OXFORDSHIRE COUNTY COUNCIL'S RESPONSE TO CONSULTATION ON THE FOLLOWING DEVELOPMENT PROPOSAL

Application no: 15/00837/OUT

Proposal: OUTLINE - Residential development of up to 180 dwellings to include affordable housing, public open space, localised land remodelling, compensatory flood storage and structural planting

Location: Part Land On The North East Side Of Gavray Drive Bicester

Figure 10: Indicative Movement Framework

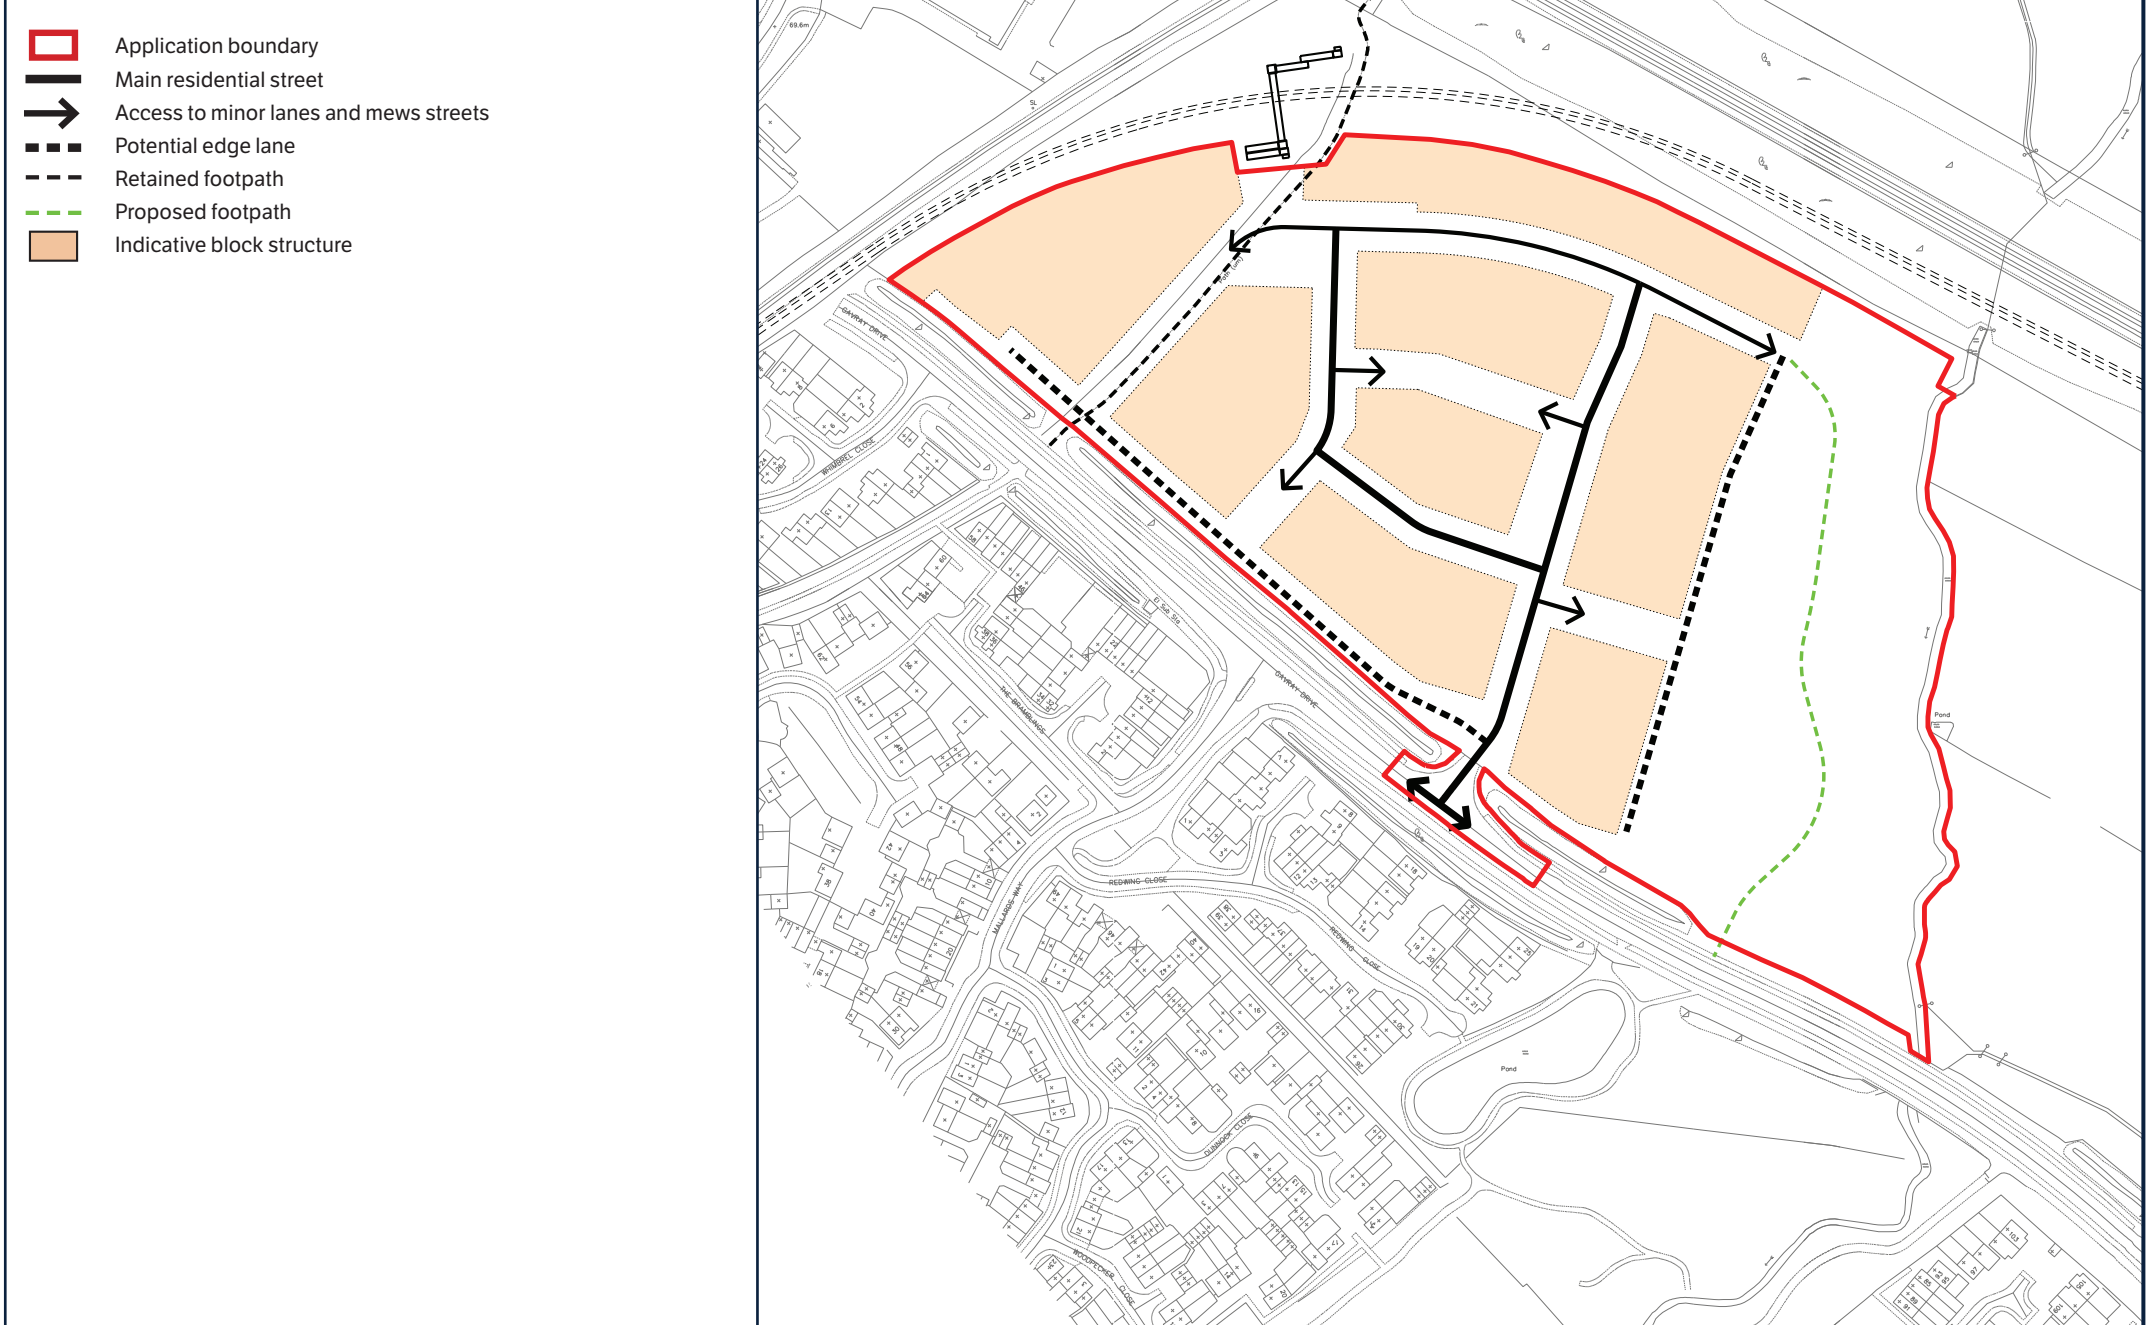
Within the site, connections should be provided through to the wider site, and the footpath towards the new footbridge over the railway will need to be surfaced and lit. Details of these connections should be required by condition.

A footpath runs across the site and over the new footbridge across the rail chord (shown on the plans). The footpath will need to be diverted at the point where it runs over the railway bridge. A surfaced path must be provided by the developer to link to the steps of the footbridge. This must follow the existing alignment as far as possible and must be sensitively planned into the development as a distinct path.

Q:\14-033 - Gavray Drive, Bicester\Tech\Acad\Drawings\14-033-009 REV B Proposed Site Access.dwg

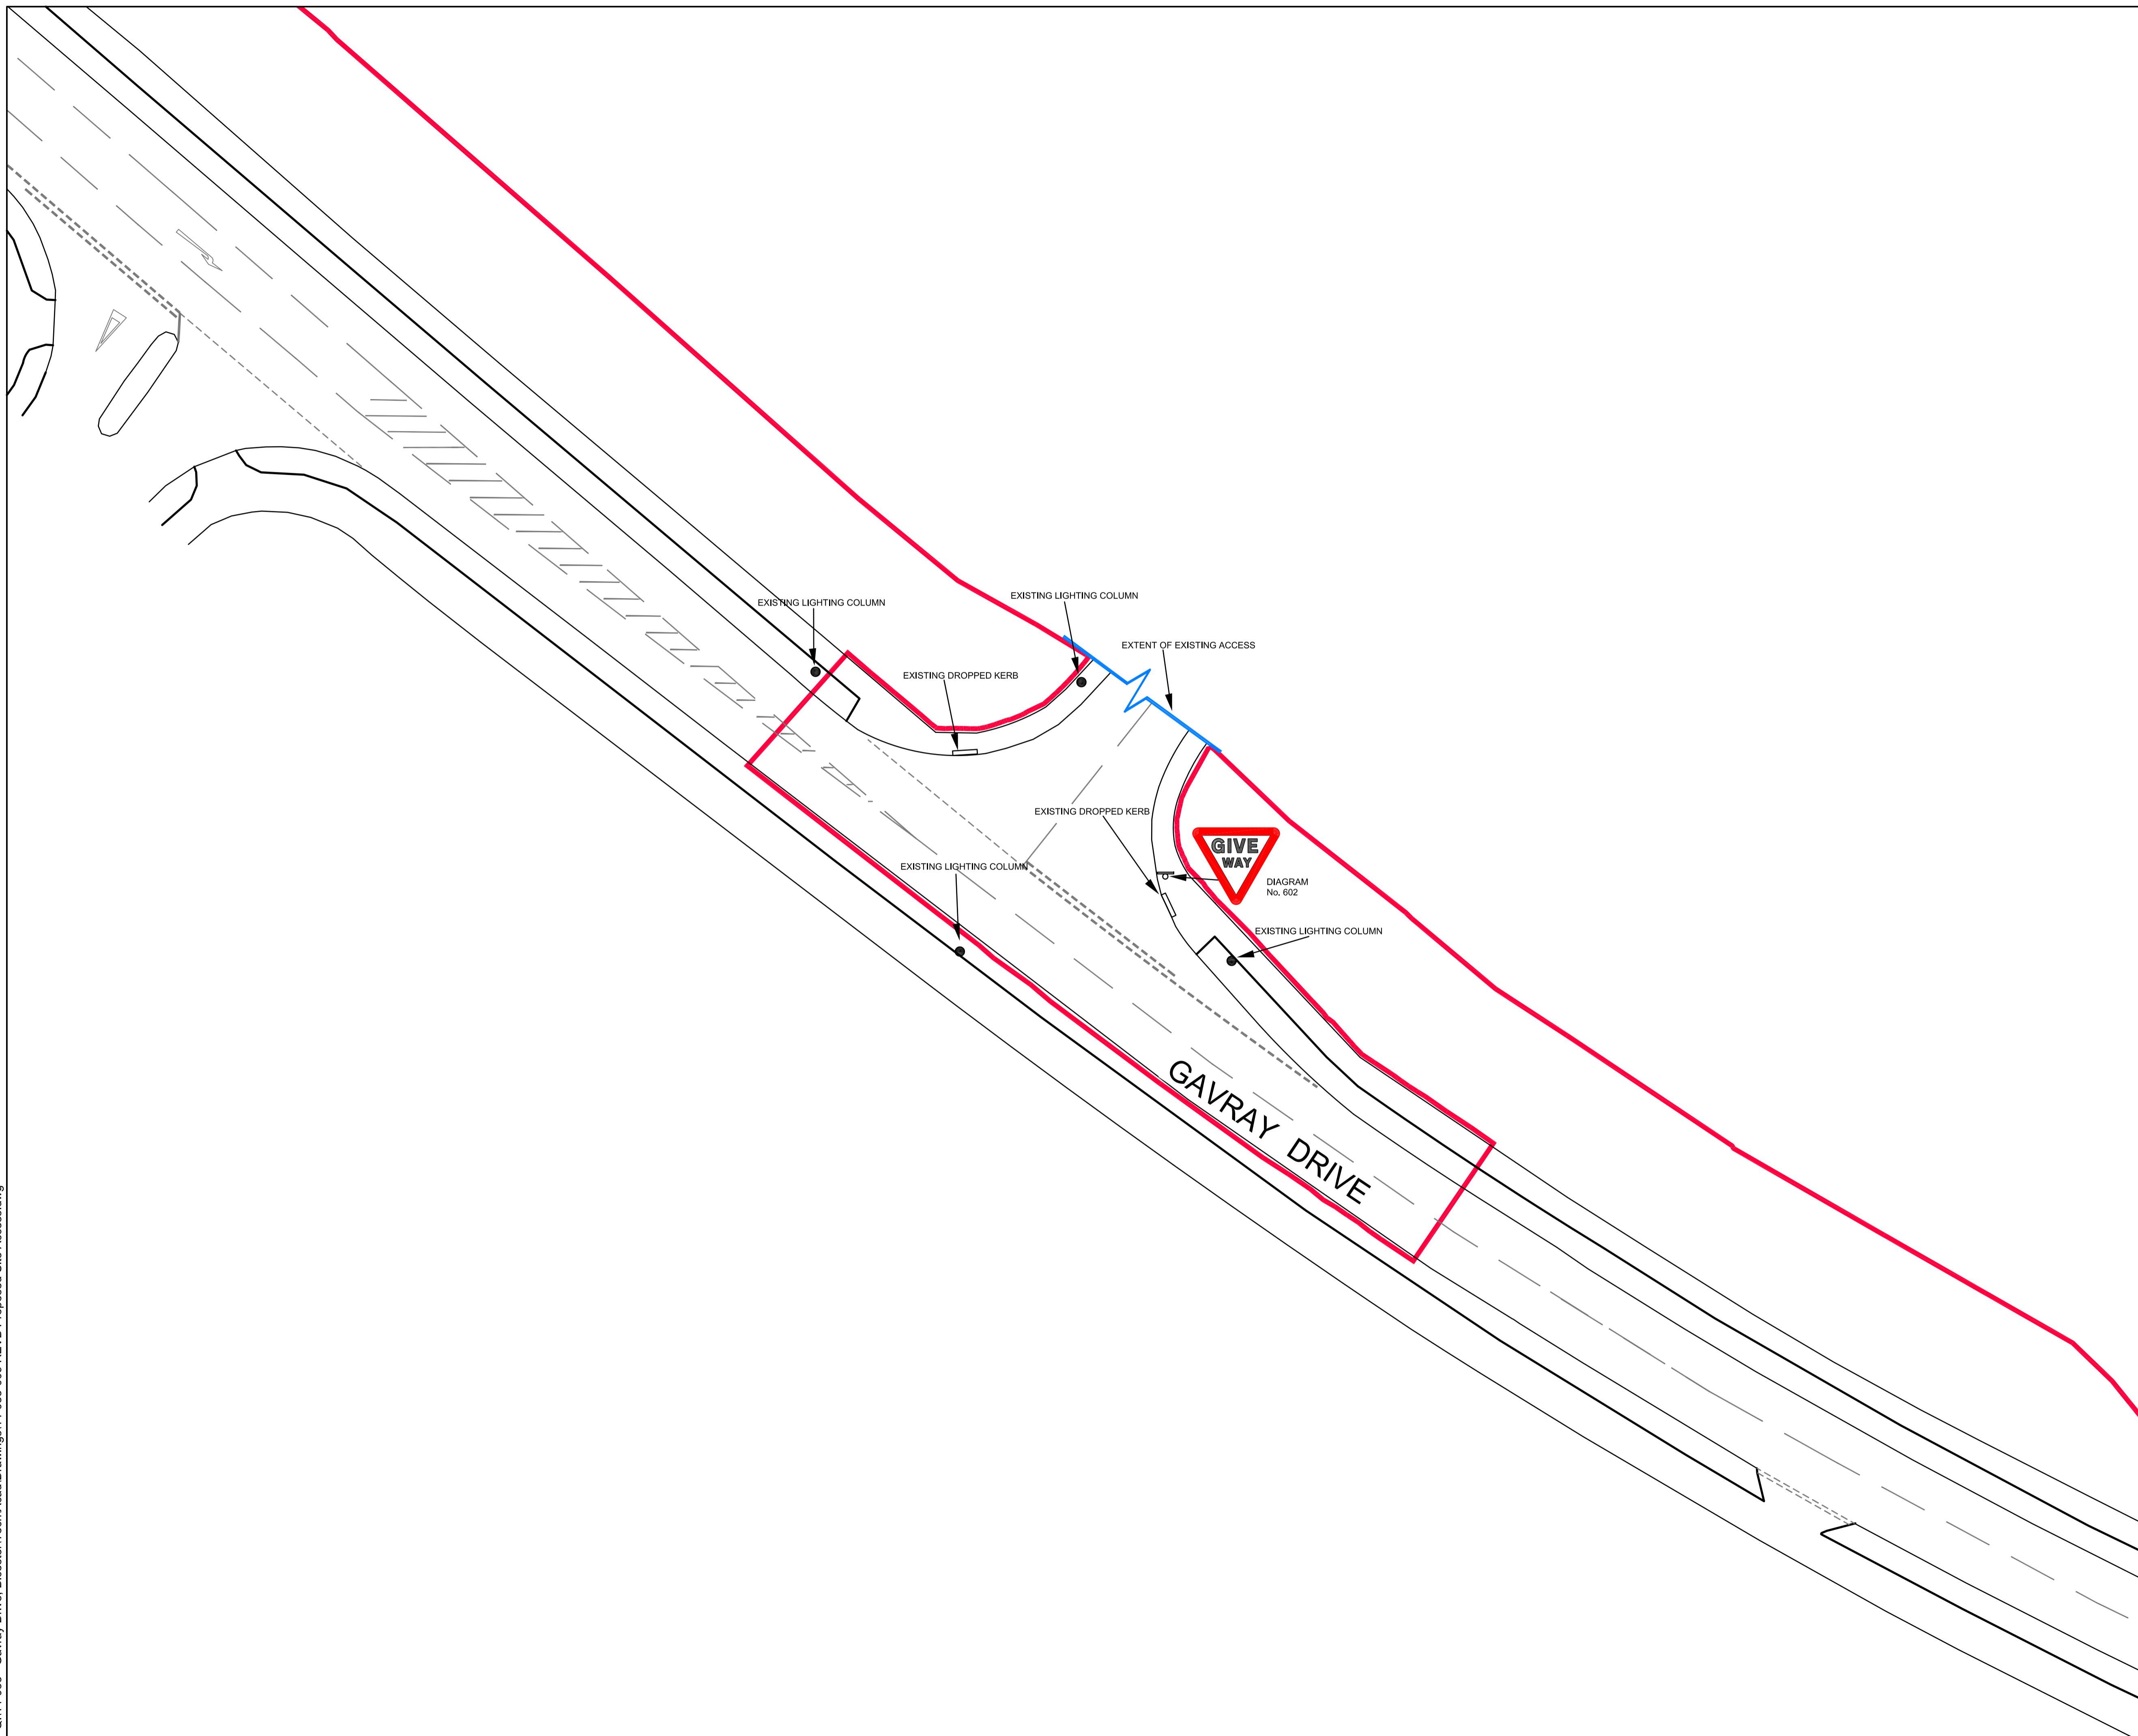
- Works on Gavray Drive to include vehicle access, pedestrian and cycle access, safe crossing points across Gavray Drive, and raised crossing across Mallards Way
- Signalised crossing of Wretchwick Way (to allow residents to cross safely to and from the southbound bus stop) plus hardstanding for bus stops

Drawings for the above have not been agreed. Indicative drawings will need to be agreed as part of the S106.

- Connection points at the northern and southern end of the site, with crossings over Gavray Drive to the existing cycle facility on the SW side.
- A raised crossing of Mallards Way.

These should be done as S278 works in connection with the site access, secured via the S106 agreement.
